KITTITAS COUNTY
DEPARTMENT OF PUBLIC WORKS

MEMORANDUM

TO: Mackenzie Moynihan, Staff Planner, Community Development Services
FROM: Randy Carbery, Planner II *RC*
DATE: January 8, 2008
SUBJECT: Schmaus No. 4 Plat

Our department has reviewed the Short Plat application and has the following comments:

**SCHMAUS No. 4 PLAT**  
PTN. SW1/4 OF SECTION 21, T.20N., R.14E., W.M.  
KITITAS COUNTY, STATE OF WASHINGTON

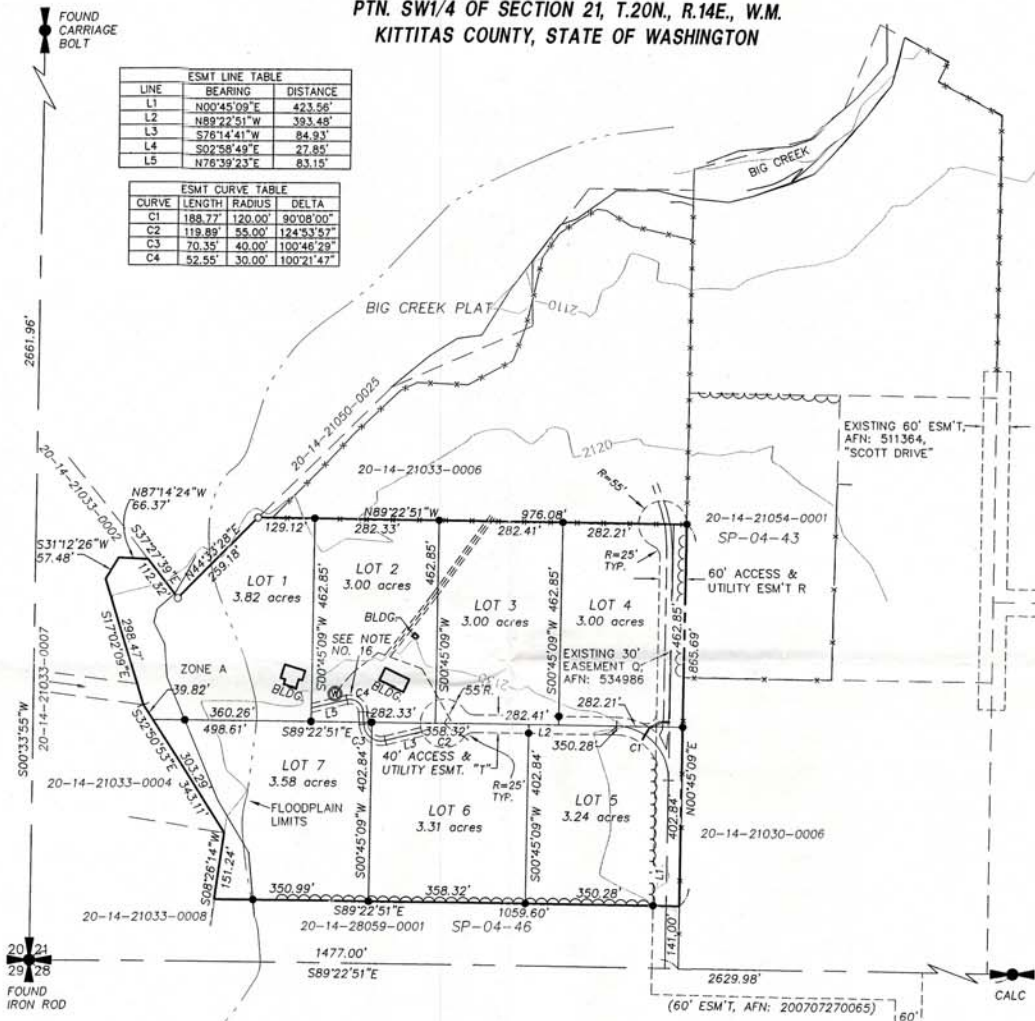
2. Private Road Improvements Access Easement "T": Access Easement "T", as shown on the face of the plat, shall be constructed as a Low-Density Private Road. See Kittitas County Road Standards, 9/6/05 edition.

- a. Access easements shall be a minimum of 60' wide. The roadway shall have a minimum width of 20', with 1' shoulders, for a total width of 22'.
 - b. Minimum centerline radius will be 60'.

- c. The surface requirement is for a minimum gravel surface depth of 6".
 - d. Maximum grade is 12%.
 - e. Stopping site distance, reference AASHTO.
 - f. Entering site distance, reference AASHTO.

3. Private Road Improvements Access Easement "Q": Access Easement "Q", as shown on the face of the plat, shall be constructed as a Low-Density Private Road. See Kittitas County Road Standards, 9/6/05 edition.

- a. Access easements shall be a minimum of 60' wide. The roadway shall have a minimum width of 20', with 1' shoulders, for a total width of 22'.
 - b. Minimum centerline radius will be 60'.

- c. The surface requirement is for a minimum gravel surface depth of 6".
 - d. Maximum grade is 12%.
 - e. Stopping site distance, reference AASHTO.
 - f. Entering site distance, reference AASHTO.

- j. All easements shall provide for AASHTO radius at the intersection of county road.
4. Cul-de-Sac: Permanent dead-end streets shall have a turn-around having an outside right-of-way easement diameter of at least 110' (55' radius) at the closed end. See Kittitas County Road Standards, 9/6/05 edition.

5. Joint-Use Driveway Access Easement "U": Access Easement "U", as shown on the face of the plat, shall be constructed as a joint-use access. See Kittitas County Road Standards, 9/6/05 edition.

- a. Access easements shall be a minimum of 20' wide. The roadway width shall have a minimum width of 12'.
 - b. The surface requirement is for a minimum gravel surface depth of 6".
